Region: South  
Division: New Mexico  
City: ALB - Albuquerque  
Site: Stormcloud 5

## Stormwater Site Inspection Report

Inspection Date: 5/7/2020  
Date/Time Entered: 5/7/2020 4:30:05 PM EST  
Report #: 392491  
Permit #: NMR10012Y  
Permit Expiration Date:  
NOI Start Date: 1/29/2018

**Erosion Sediment Control Plan**

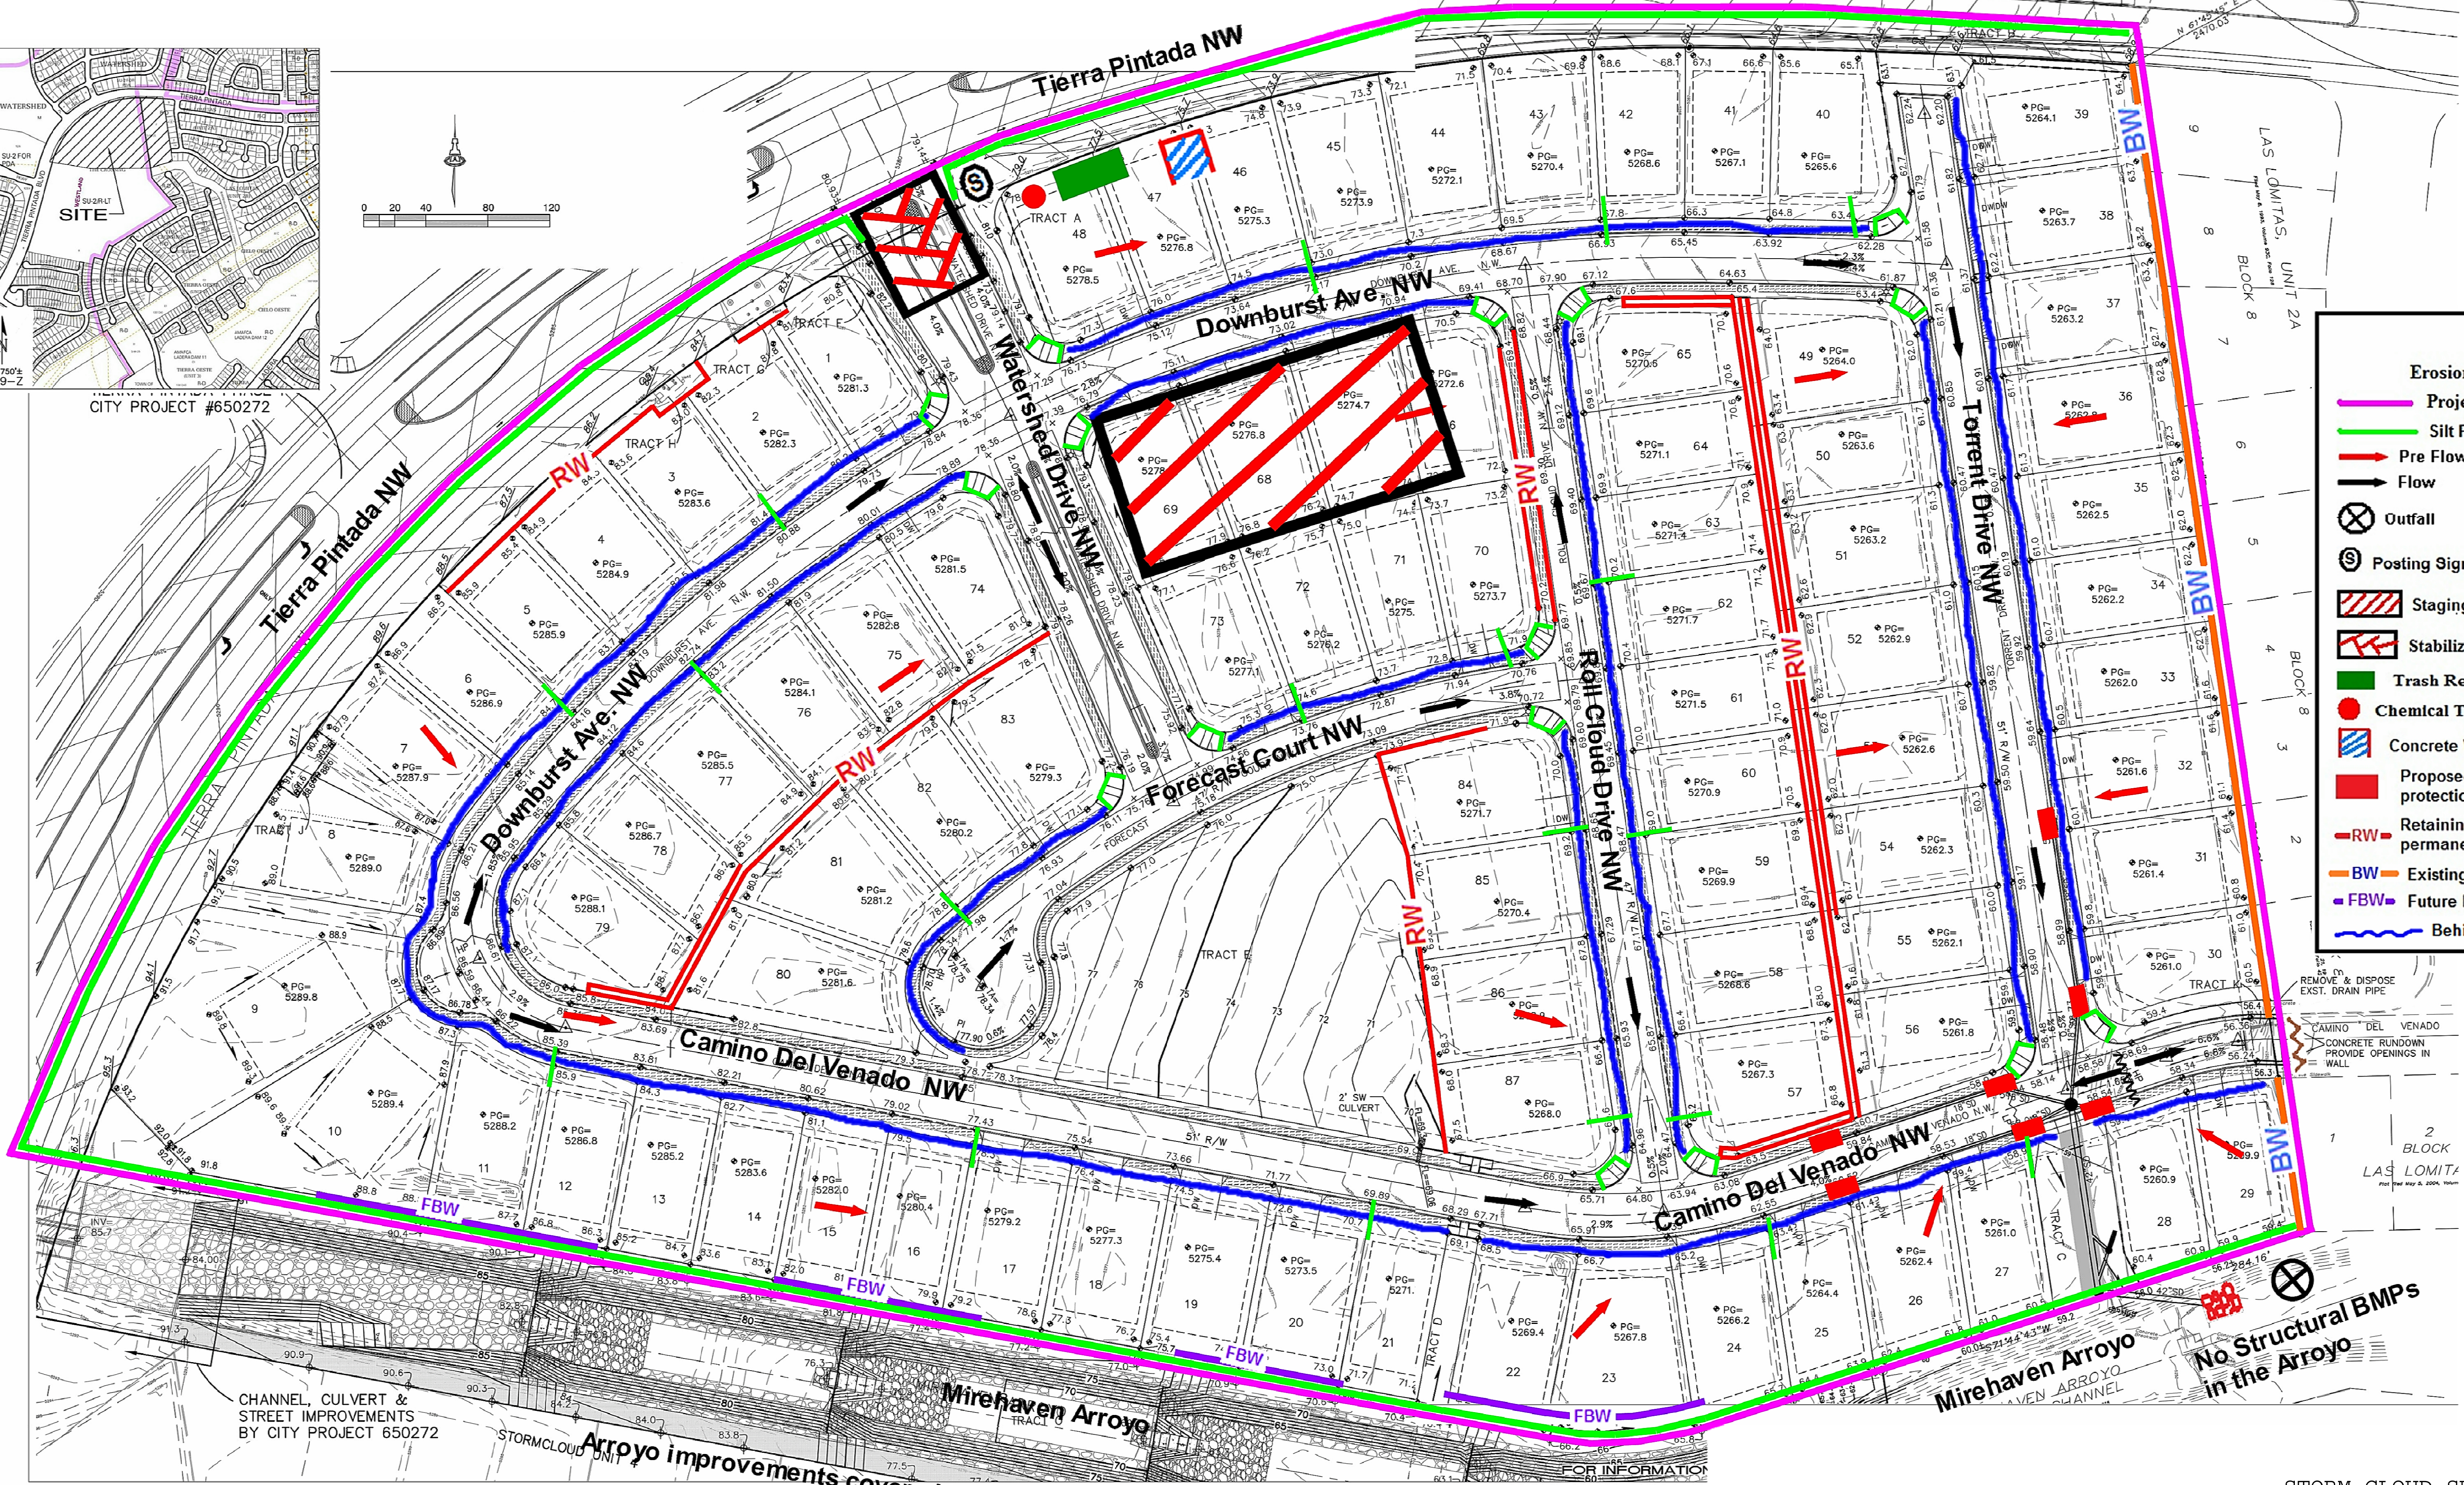
| B. Vehicle Tracking: Installed and maintained per SWPPP?                                     | No  |

Ref#	Deficiency(Action Item)	Location	Verified By	Date	Responsive Action Taken
392491 - B1	Re fresh VTC	8508 camino del venado
